Hornsea Project Four

Applicant's comments on other submissions received at Deadline 5

Deadline 5a, Date: 4 July 2022

Document Reference: G5.30

**Drawing No:** 172950\_PLN\_INFO\_Dransfield\_A

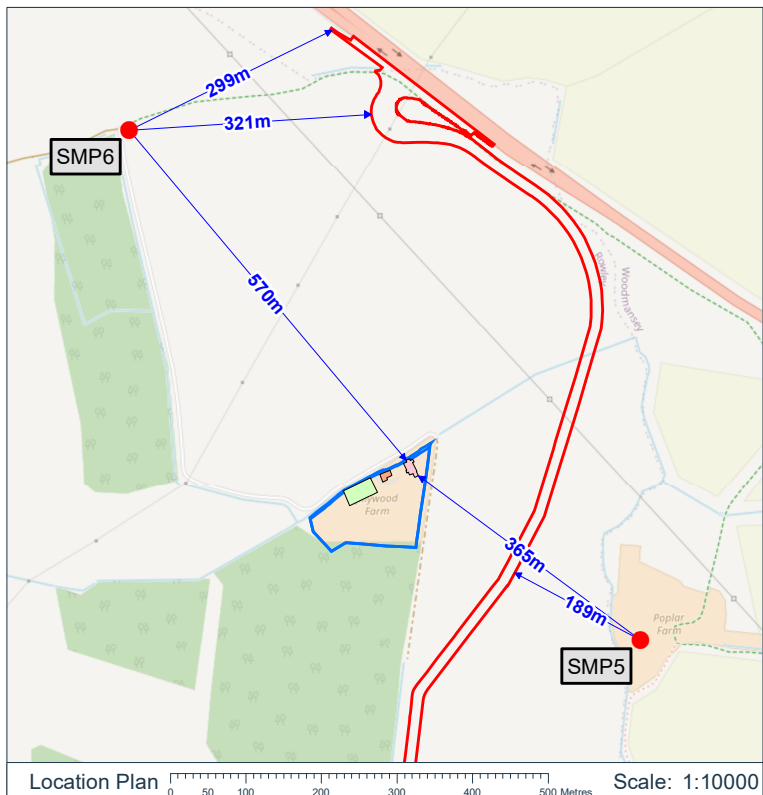
Reference	Stakeholder's Written Representation	Applicant's Response
		<ul style="list-style-type: none"> Proximity to Mr and Mrs Dransfield's property at Jillywood Farm and adverse amenity impacts – The site selection process for Hornsea Four has considered hundreds of residential properties across the wider study area. No one residential property has been favoured above another and commitments made by the Applicant to locate development works specific minimum distances from residential receptors (Co49, Co134, Co135) were made to minimise the potential for amenity impacts to occur. The Applicant highlights that the habitable buildings and tennis court at Jillywood Farm are all over 150m from the OnSS access track (see REP5-079) and noise and visual impacts at Jillywood Farm during both construction and operation have been assessed as being not significant; Interaction with Flood Zone 3 – please see the Applicant's responses to Targeted Consultation (in APP-133, and repeated in Appendix A of REP5-074); Interaction with existing power lines and high-pressure gas pipeline - please see the Applicant's responses to Targeted Consultation (in APP-133, and repeated in Appendix A of REP5-074); and Consultation adequacy – the Applicant has explained numerous times why it considers its statutory consultation to have been adequate and does not propose to provide a further response on this topic (see REP5-074 for a summary of the Applicant's responses).
